Application Reference: 2025/0221

Site Address: 41 Mayfield, Oxspring, Sheffield, S36 8YN

Proposal: Variation of condition 2 of application 2024/0614 - (to comply to Building Control Thermal Constraints) Removal of gate, shed and fence, and erection of single storey detached outbuilding at side of 2 storey semi-detached dwelling

PROJECT	Detached Home Office
CLIENT	Mrs. Aimee Parsons
TITLE	Elevations
ADDRESS	41 Mayfield, Oxspring, Penistone, Sheffield. S36 8YN
DRAWN BY	ggg
SCALE	1:100 © A3 DATE Mar 25
DRAWING No	823-11 REV A
Member of the Chartered Institute of Architectural Technologists

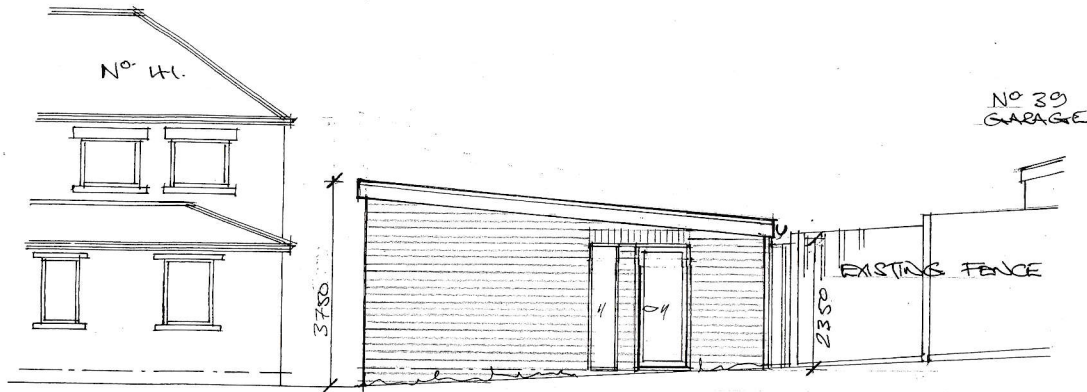
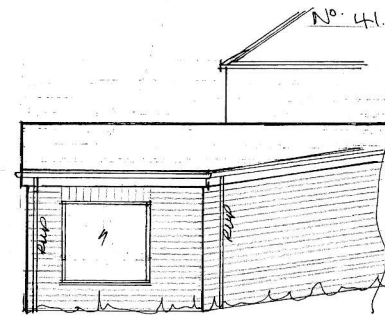
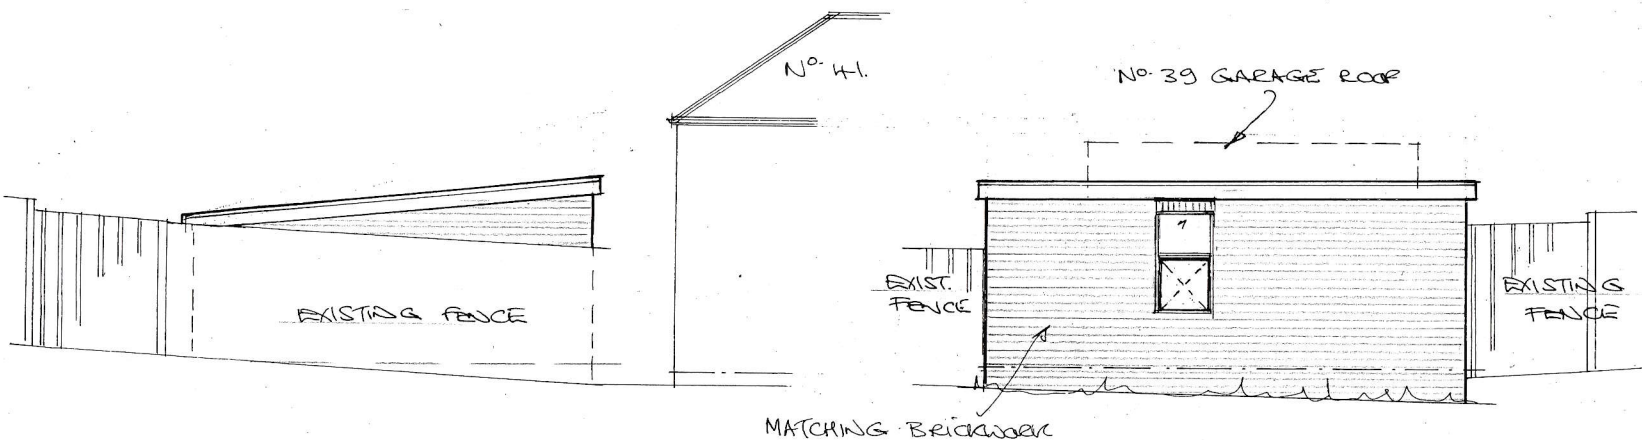
The proposal seeks to vary condition 2 of approved planning application 2024/0614, to allow for an alternative roof to be installed than that detailed on the approved plans. The proposed roof would be of a similar height but of constructed differently, using different materials. The existing approved outbuilding would feature a single pitched roof with an approximate lowest height of 2.2m, extending to a maximum height of 3.78m. The proposed new heights would be approximately 2.75m, extending to a maximum height of 3.75m. Additionally, as the approved tiled roof would be difficult to install without significantly increasing the pitch and subsequent height of the roof, the roof now proposes to use a Ruberoid material and would feature a slightly increased pitch.

Whilst there is a small impact regarding the scale of the proposal, the resulting impact on the associated dwellinghouse or upon the street scene would be very minimal and would realistically not introduce any noticeable impact to the scale of the approved as already approved. Therefore the impact on the scale of the proposal would be limited.

With different roofing materials, the design of the proposal would be altered from that which was approved. In mitigation of this, the proposal is for an outbuilding rather than an extension, so it would not be uncommon for such an outbuilding to feature such a roof design. Furthermore, if the outbuilding was not constructed beyond the front elevation of the dwelling, a similar outbuilding constructed through permitted developments would have no restrictions on material choices for either the walls or roof. On balance whilst the original application and this amendment do require planning consent, the new roof materials would only be considered to have a modest impact to the overall design of the outbuilding, and an equal impact upon the character of the original dwelling.

There was considered to be potential, and limited impact from the proposal on a single neighbouring dwelling of No.39 Mayfield. With only a small increase in roof pitch but no overall increase in roof height it would be considered that the impact on most neighbouring dwellings would remain little or none, and any impact on No.39 would remain limited.

For the reasons given above and taking all other matters into consideration the changes proposed would not have any significantly greater impact on neighbouring amenity, residential amenity or visual amenity compared to what has been previously approved. On balance the scheme is therefore considered acceptable.
